# CITY OF MERCER ISLAND

RE: Request for Information #1 for File No. SUB21-006, CAO21-004, SEP21-022 – Milestone Short Subdivision  
7621 SE 22<sup>nd</sup> ST, Mercer Island, WA 98040; King County Tax Parcel # 531510-1846

The City of Mercer Island received the resubmittal for SUB21-006 on September 1, 2021 addressing the Incompleteness Letter dated 7/20/2021. In addition, the City of Mercer Island received the submittal for a Critical Areas Review 2 (CAR2) application and SEPA Review application on September 1, 2021. The CAR2 application was assigned application #CAO21-004 and the SEPA Review application was assigned #SEP21-022. The applications were determined to be complete on October 21, 2021. Following review of the applications listed above, City staff has determined that additional information is necessary to ensure compliance with the Mercer Island City Code (MICC). Please note that further review of this application is on hold until the following information is provided by the applicant (application status is "WCI" Waiting Customer Information). Please provide the following items:

# RAND-MILESTONE 3 LOT PRELIMINARY SHORT PLAT

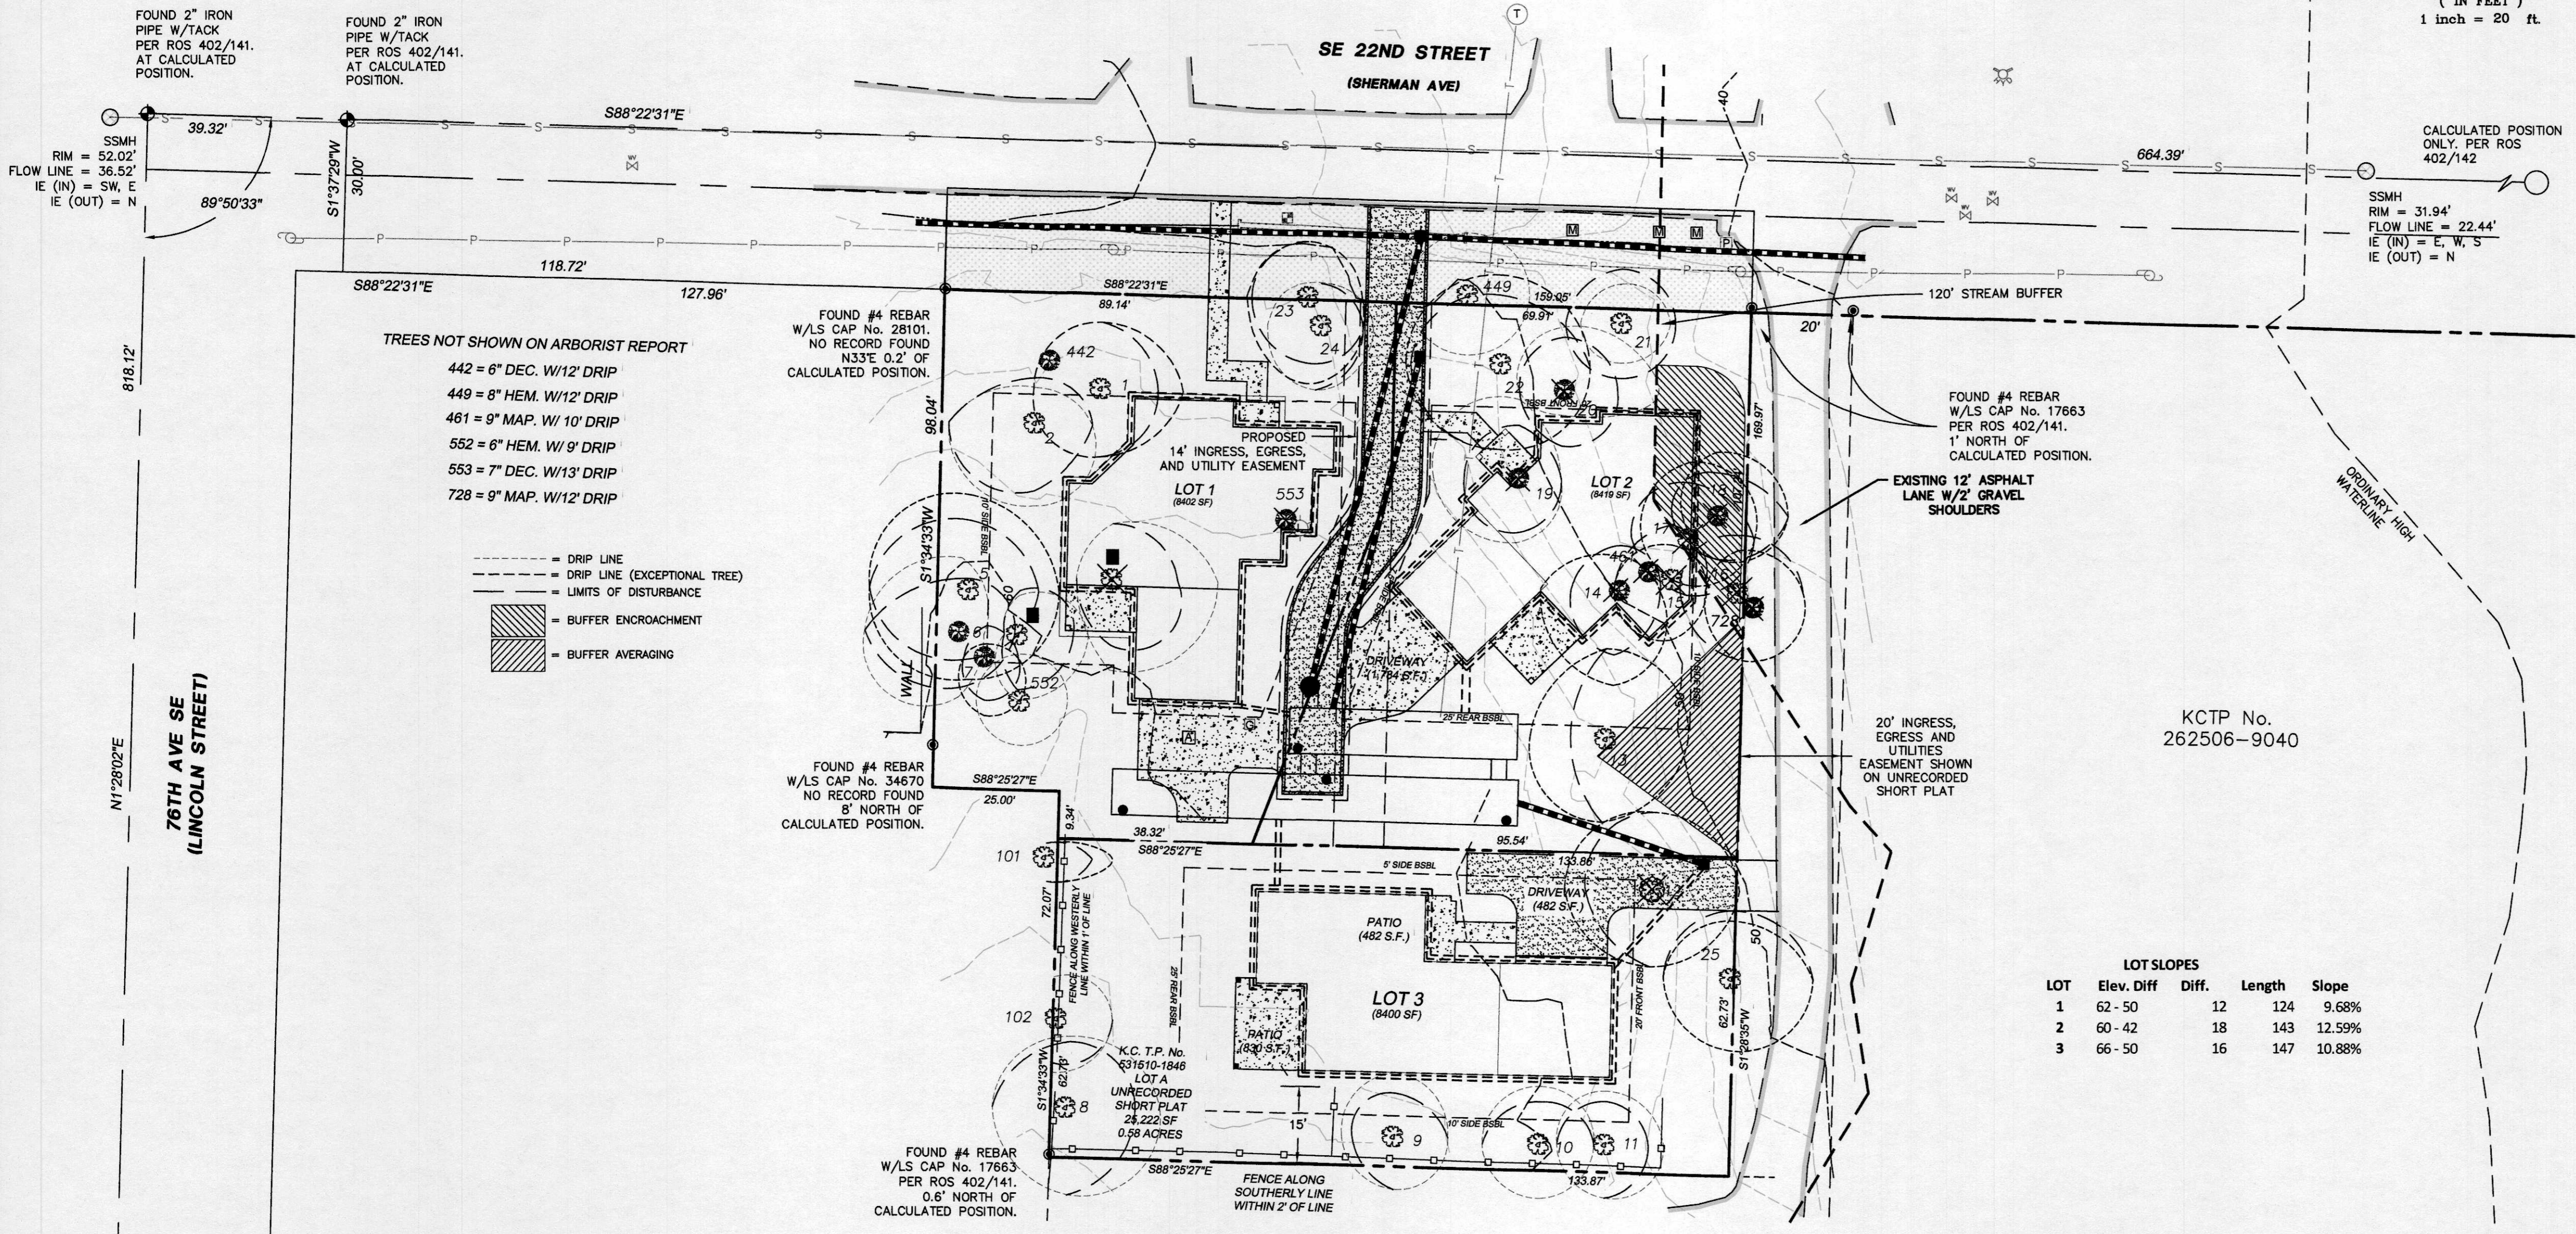
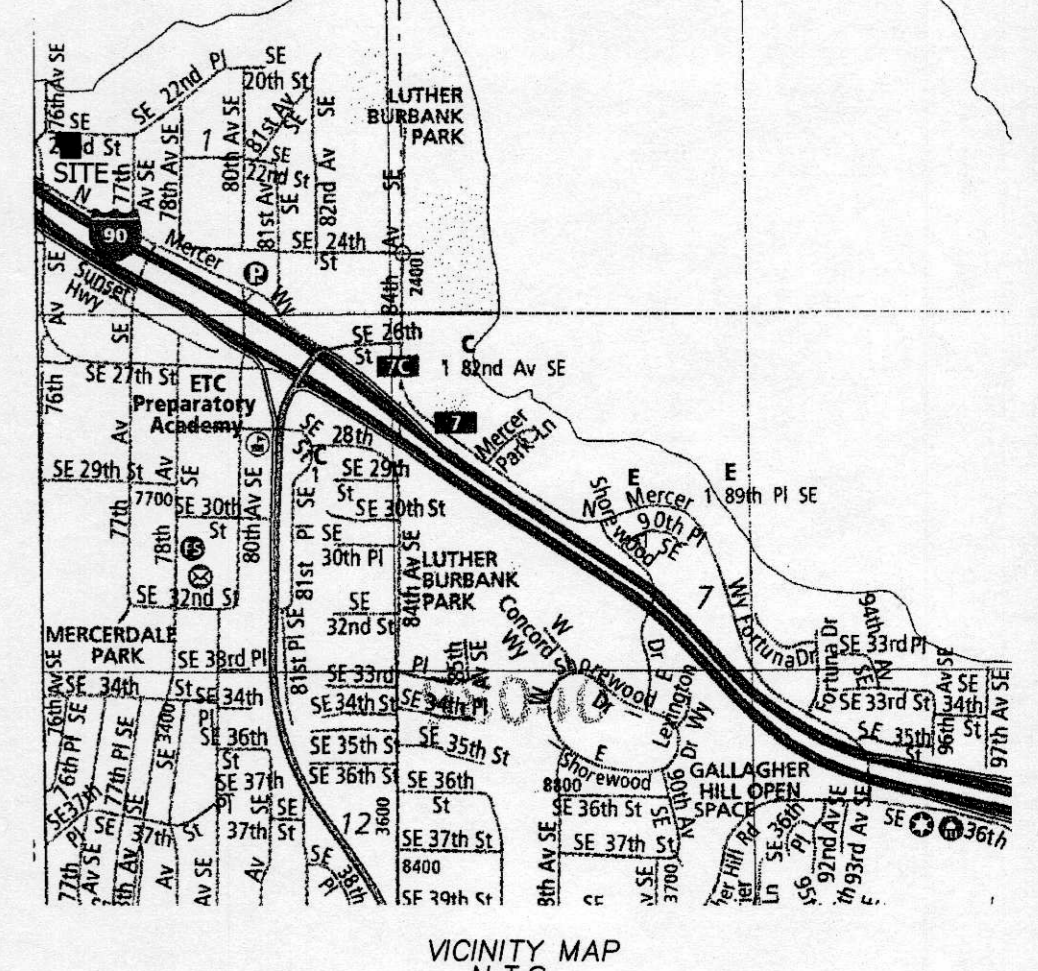
3. Please add the following note to the plat:

"All buildings are subject to meeting the current fire code requirements at the time of permit submittal. Access shall be provided as outlined in the International Fire Code Appendix D as adopted and/or amended and MICC 19.09.040. Fire plan reviews will be conducted at the time of building permit submittal and may require additional fire protection systems and/or fire prevention measures for permit approval."

4. Building Pad:
  - a. Please illustrate and label the three (3) building pad areas that comply with MICC 19.09.090. In general, the building pad excludes setbacks and avoids and minimizes impacts to the following: trees, vegetation, topography, and critical areas (geohazards and buffer averaging area).

10. Easements:
  - a. Please clearly distinguish the existing easements within the plan set.
  - b. Clearly distinguish the private easements from public easements within the plan set.
  - c. Note the recording numbers for all existing easements within the plan set.
11. Please provide a plat map only showing the old lot lines with bearings and distances, an all existing easements and proposed easements.
